**KIRKLEES METROPOLITAN COUNCIL
INVESTMENT & REGENERATION SERVICE**

DELEGATED DECISION TO DETERMINE PLANNING APPLICATIONS

Reference No: 2021/62/91124/E
Site Address: 123, Foxroyd Lane, Thornhill, Dewsbury, WF12 0NA
Description: Erection of single storey front extension
Recommending Officer: Jennifer Booth

DECISION – REFUSED

BLOCK PLAN

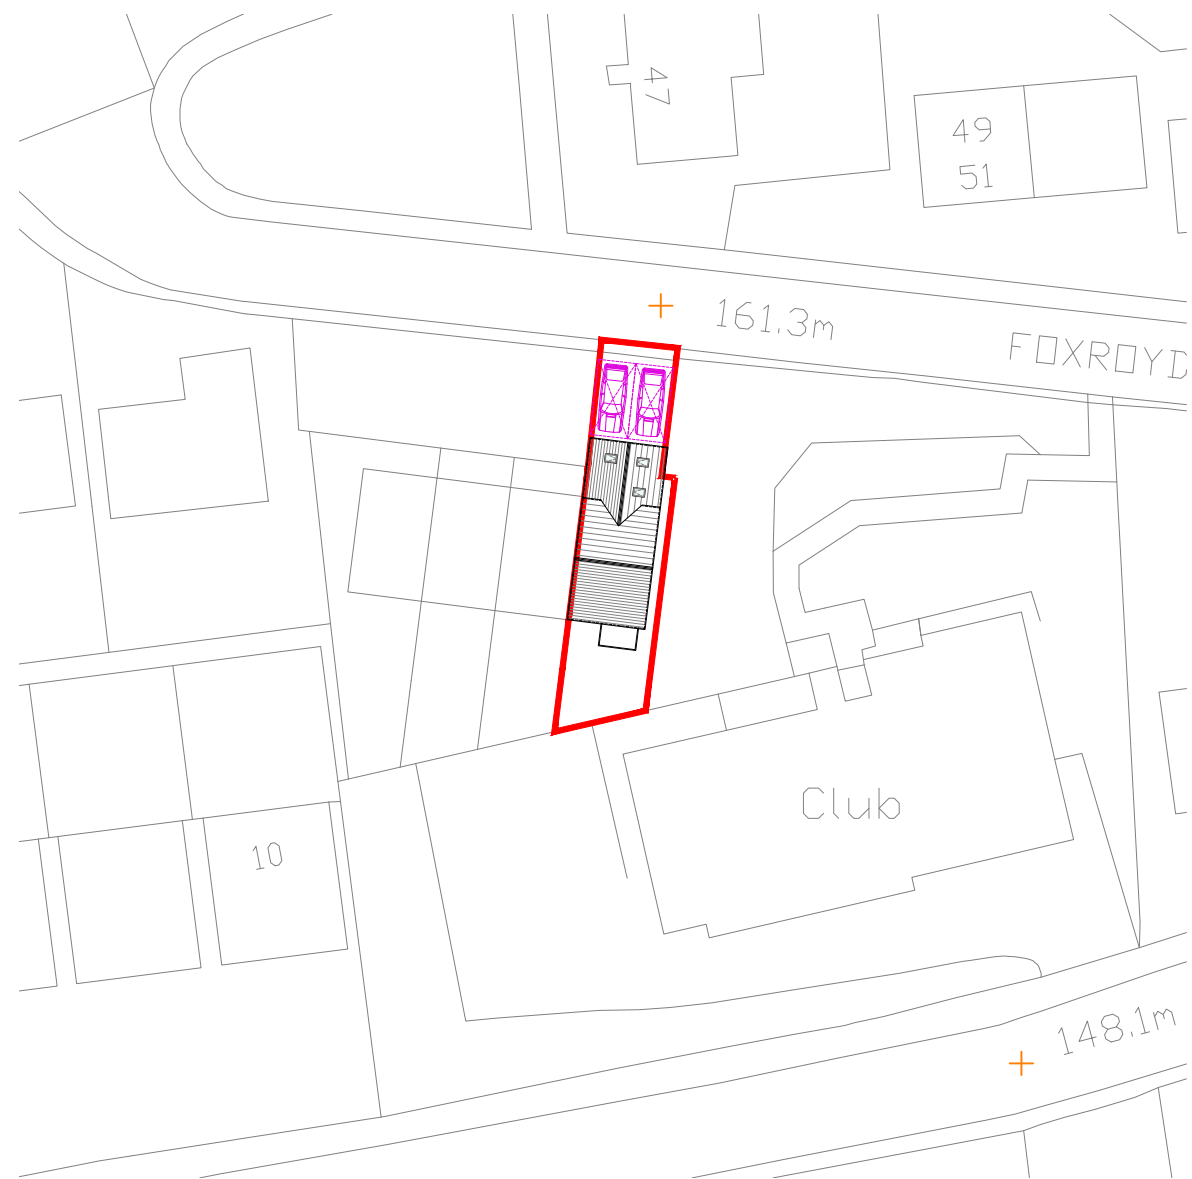
This would result in a large extension along the shared boundary with the adjoining 125 Foxroyd Lane. However, the opening closest to the boundary is a door and the space to the front of the neighbour is a parking area. Officers are satisfied, therefore, that there would not be a significant impact on the amenities of the occupiers of the adjoining 125 Foxroyd Lane.

The proposals will result in some intensification of the domestic use. However, the parking area to the front of the property would still be able to provide two off-road spaces, which is considered to represent a sufficient provision. Therefore, the scheme would not represent any additional harm in terms of highway safety and, as such, it complies with Policy LP22 of the KLP.
